Rezoning Transportation Analysis

Petition Number: 2025-033

From: Jake Carpenter, PE

REZONING PLAN

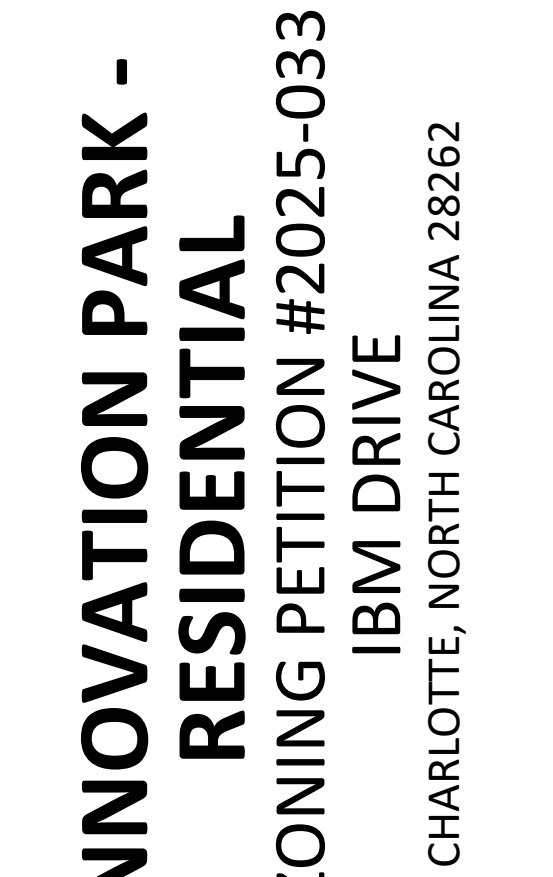
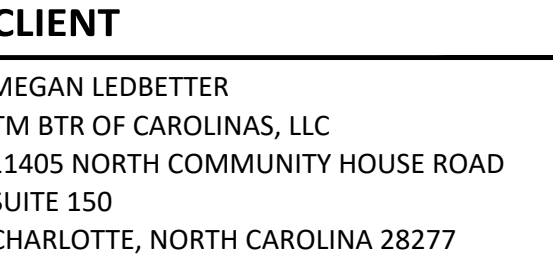
~~IBM Drive:~~ Location of future curb and gutter is to be a min of 19 feet from the roadway centerline.

~~Label and dimension the curb and gutter from the centerline for each road on the site plan.~~

- ~~3. Revise site plan and conditional note(s) to commit to dedicate right-of-way along all proposed frontages along IBM Drive from the road centerline to a min of 39-feet or back of Shared-Use Path. The site plan shall label and dimension the right-of-way from the road centerline. Where feasible CDOT request ROW to be placed 2 feet behind the Shared-Use Path or a sidewalk utility easement can be utilized.~~

~~**Clarifying Comment 05-21-25:** Revise site plan and conditional note(s) to show the proposed Shared-Use Path (SUP) inside of the proposed ROW or inside of a sidewalk utility easement (SUE) placed 2-feet behind the back of the SUP.~~

- ~~4. Revise site plan and conditional note(s) to commit to construct bicycle facilities by installing a 12' multi-use path in accordance with the council-adopted Charlotte Streets Map. Multi-use paths maintained by the City shall meet ADA/PROWAG requirements.~~

- 11. New Comment 05-21-25:** Revise site plan and conditional note(s) to minimize the jogging of the Shared-Use Path alignment. Coordinate with CDOT regarding path.
